# WORIMI LOCAL ABORIGINAL LAND COUNCIL

**RE: Stockton Quarry - Modification - 3 Stockton Sand Quarry (DA140-6-2005-Mod-3)**

Figure 4.1 Proposed expansion to extraction area

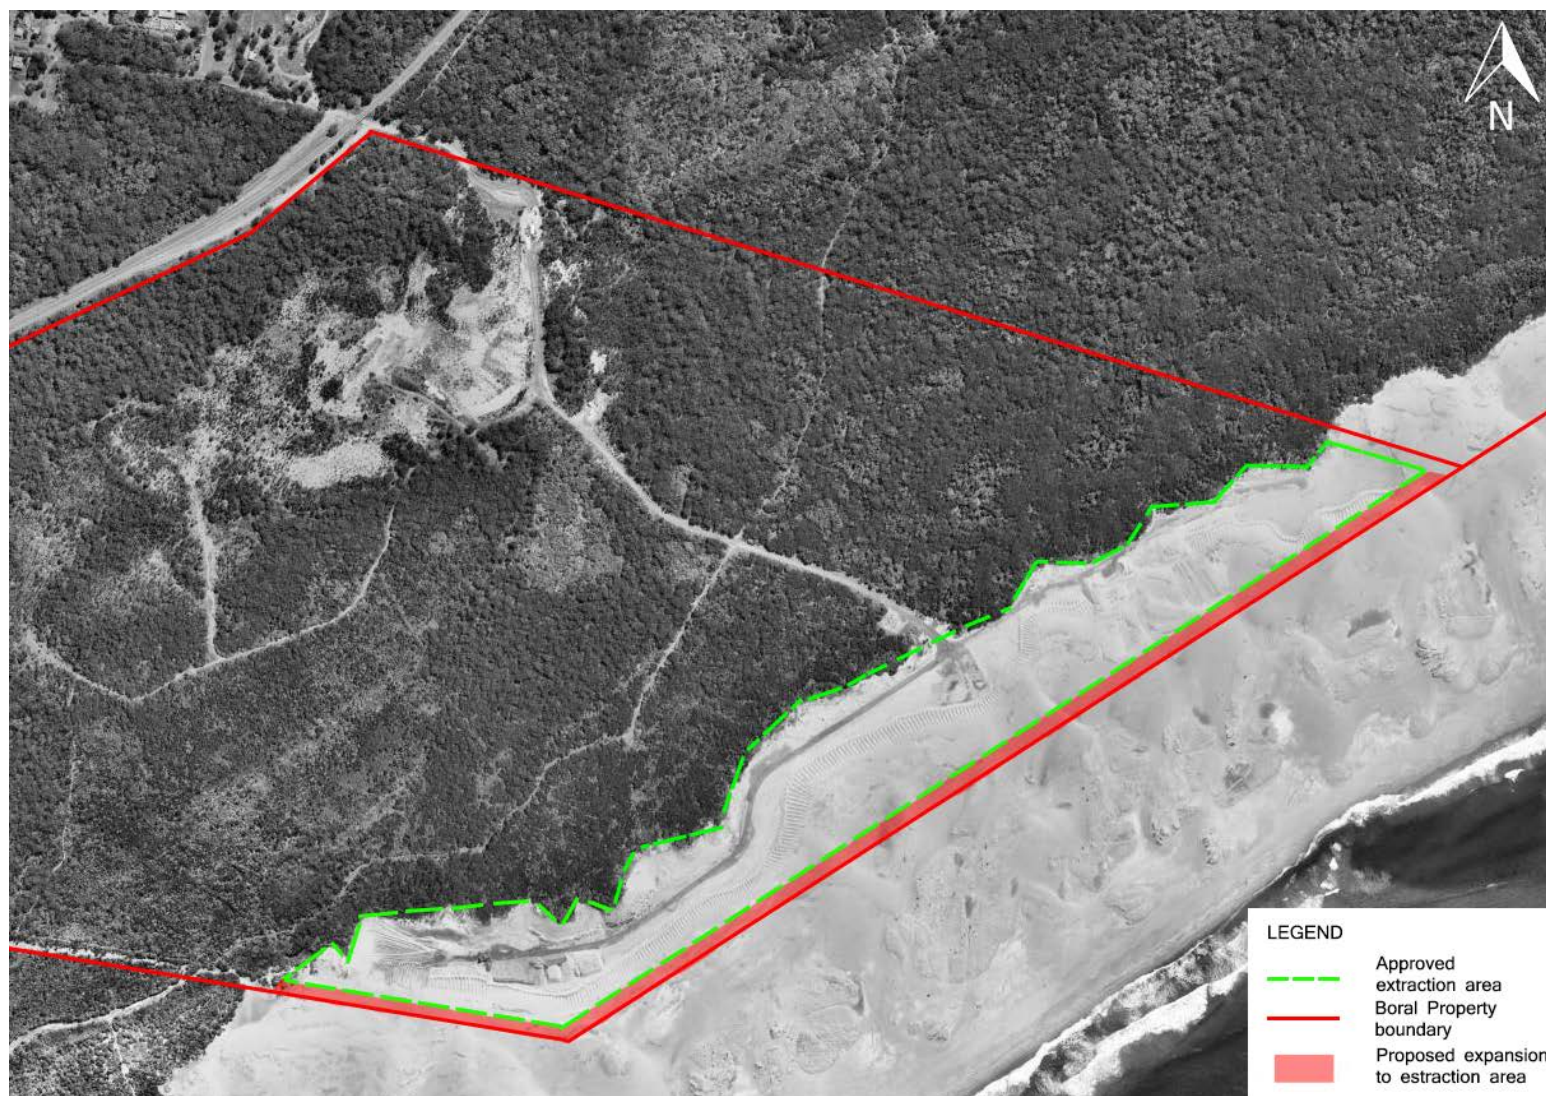
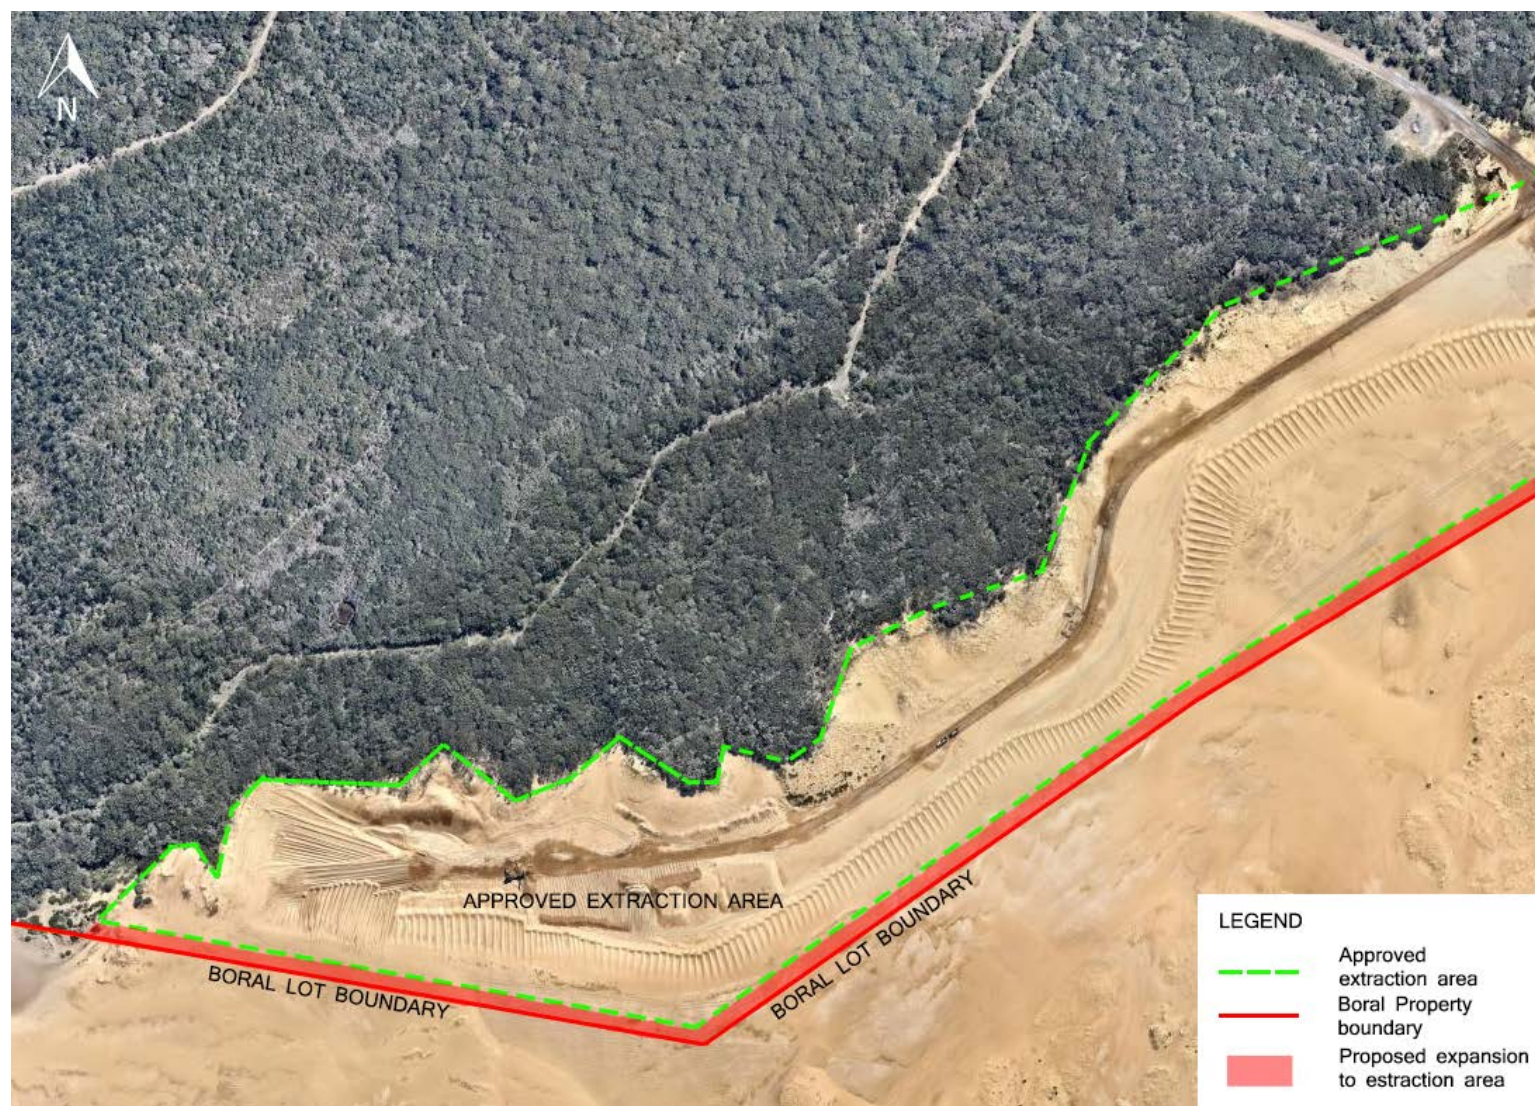
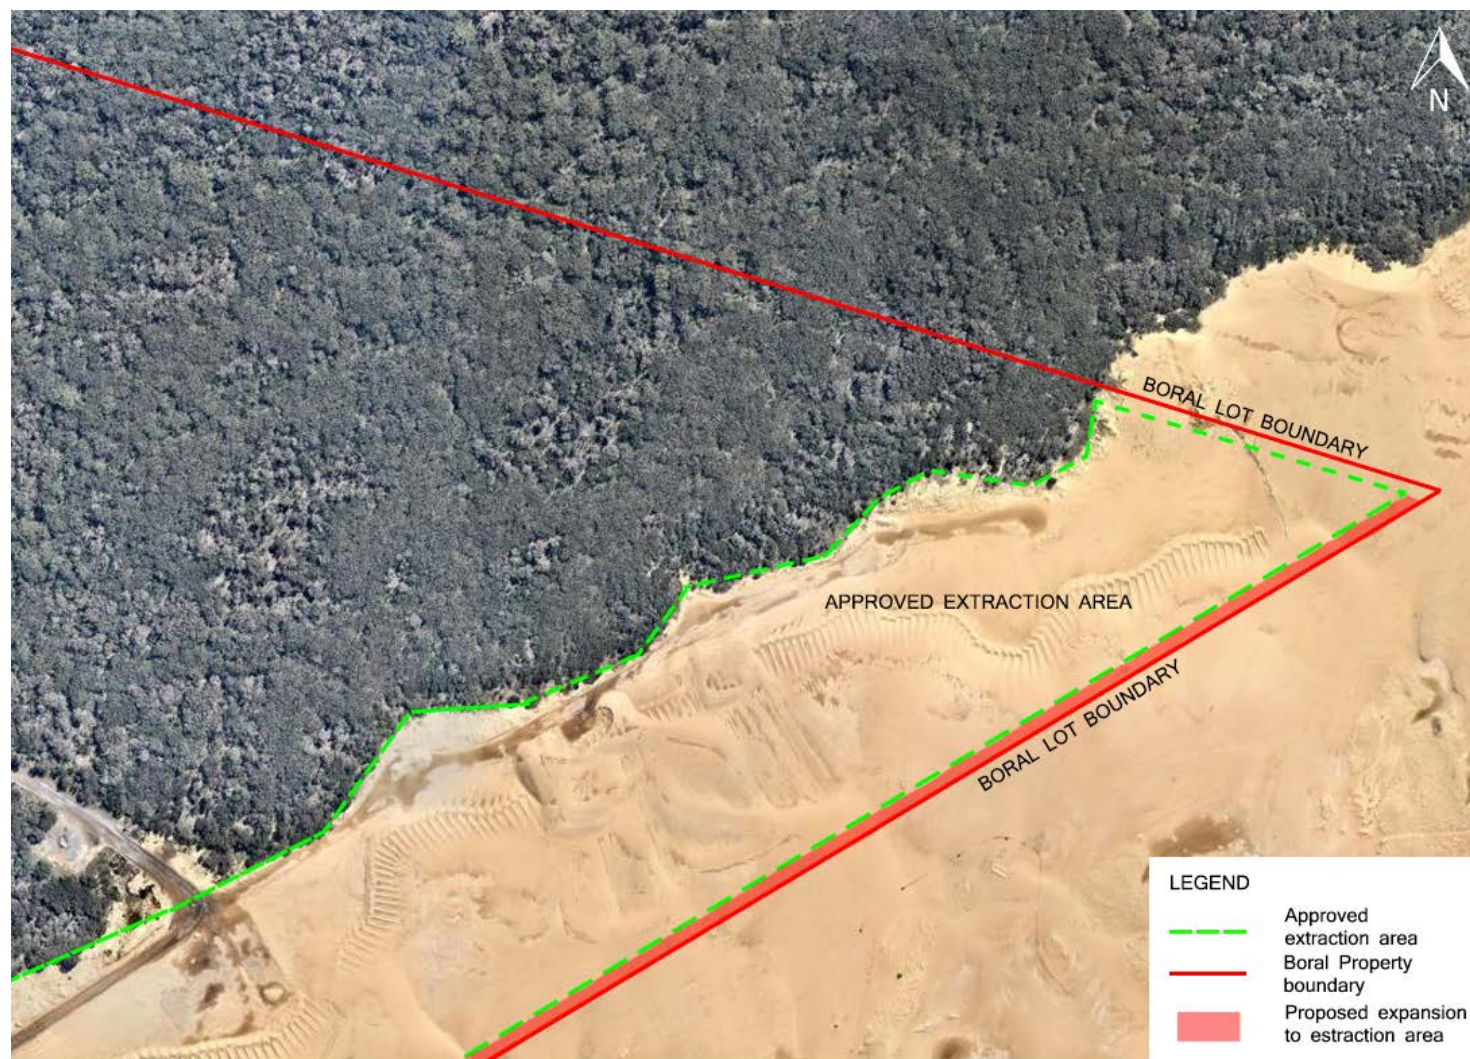
The understand that the proposal is to amend the DA to remove or reduce the 15m buffer zone from the southern half of the footprint of the existing sand extraction operation (**the buffer**), which is the predominant direction of the windblown sand movement.

1. The Windblown Project and the buffer are located in an area where the dunes are highly unstable; and already pose environmental risks under the current operating conditions being imposed by Boral.

2. The maintenance of the buffer is **critical** to ensuring the stabilisation of the adjoining land and preventing the **accelerated and unnatural movement** of sand from the WCL to the Boral Land. Worimi LALC agrees with the observation in the NPWS submission that:  
*“The proposed sand extraction extension would have the top edge of the quarry batter slope positioned directly at the boundary of the WCL. This leaves no margin for error to avoid impacts on the WCL side of the boundary. It has been acknowledged in the SEE and RtS that the 15 metre buffer performs the function of ensuring that extraction activity does not directly destabilise and effect the neighbouring land within the WCL. Sand quarried from within the 15 metre buffer area will cause the immediately adjacent dune to actively collapse into the extraction pit, further exacerbating dune deflation on the WCL.”<sup>3</sup>*

*If the buffer area is removed and only the landward batter slope in the quarry is re-vegetated, this will have no impact on stabilising the remaining dune that adjoins the WCL. In these circumstances, the proposed sand extraction extension would result in an increased extent and rate of deflation in the WCL, lowering the dune further.<sup>5</sup>*
6. Worimi LALC has already suffered the effects of this experience on other lands at Stockton where a sand extraction operation adjoining the land councils’ land occurred without an

**Figure 4.4** Cross section, showing existing and proposed pit extent/design (sections 1 and 2)

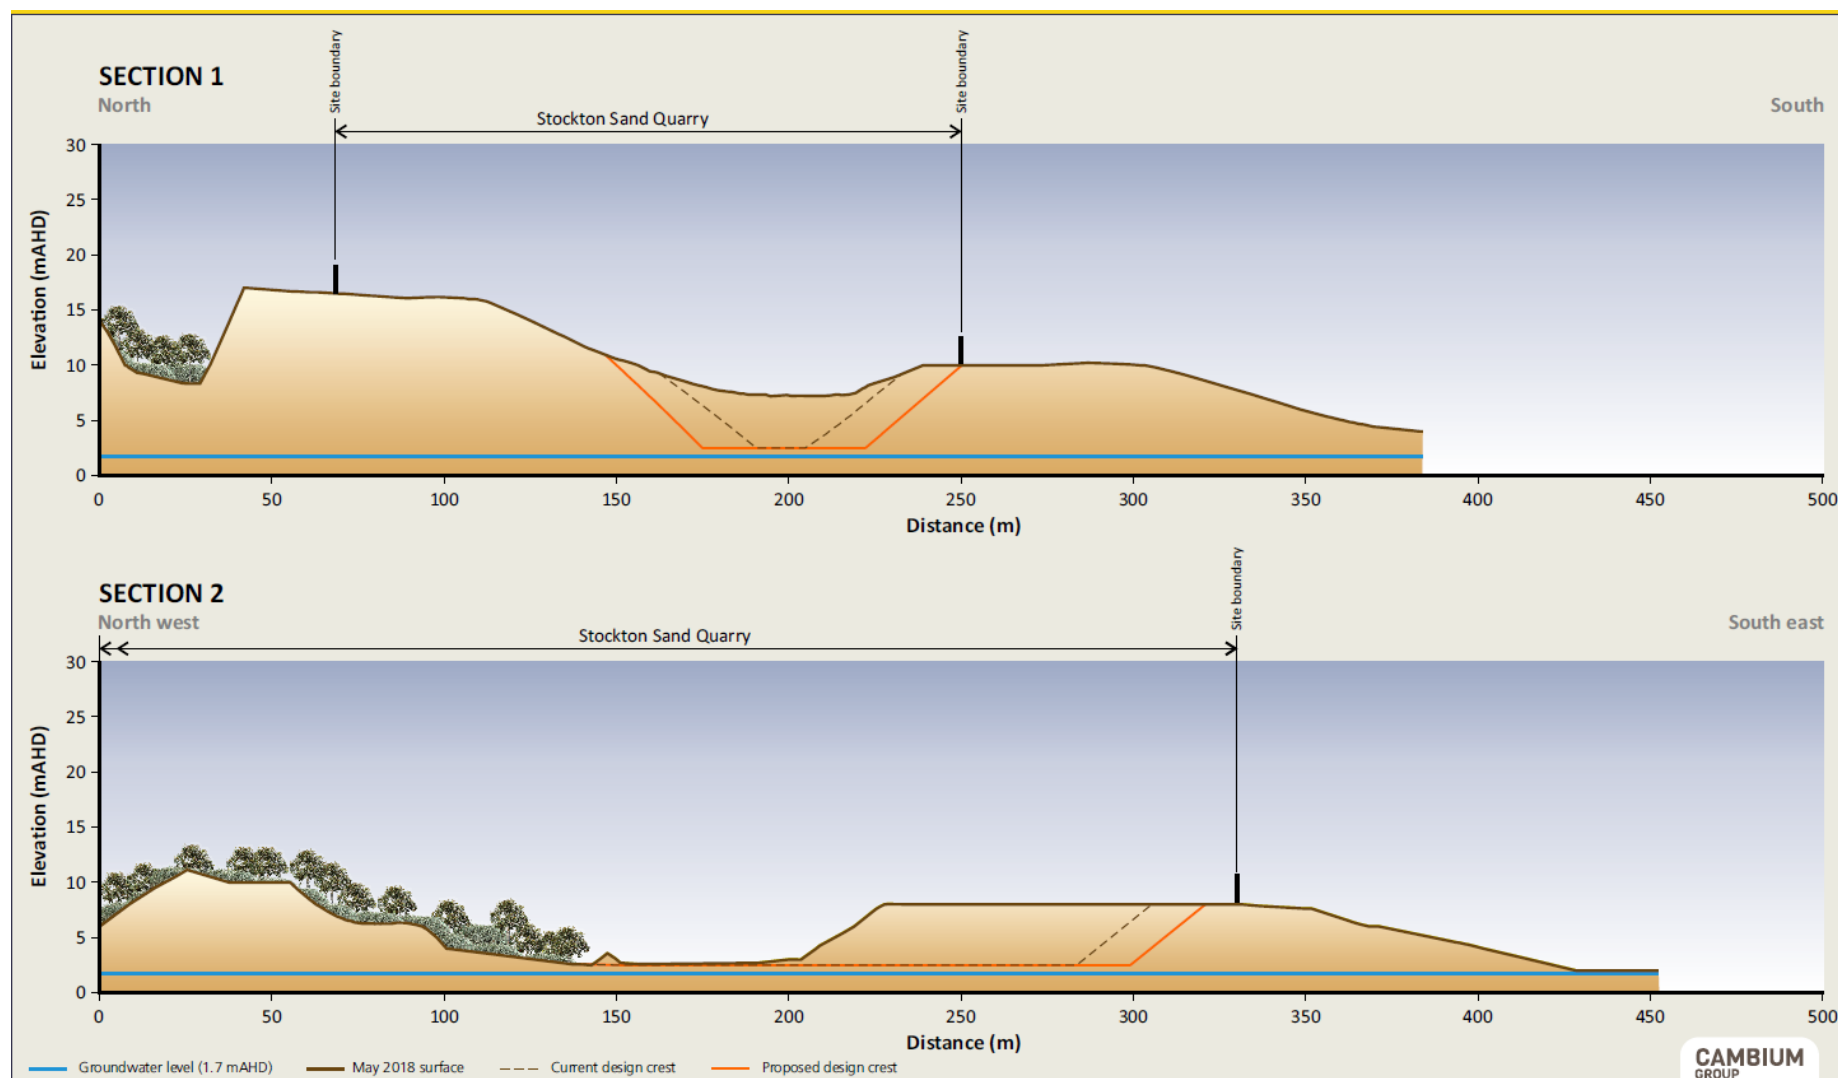
5. Worimi LALC also agrees with the observation in the NPWS submission that:  
*The EIS (2005) for the current sand extraction operation inclusive of the existing 15 metre buffer zone notes there will be a lowering of the dune beyond the Boral property. The same document also notes that without stabilising the remaining hind dune, including the 15 metre buffer, the extent and rate of deflation of the dunes beyond the Boral property will increase, lowering the dune further on the WCL.*
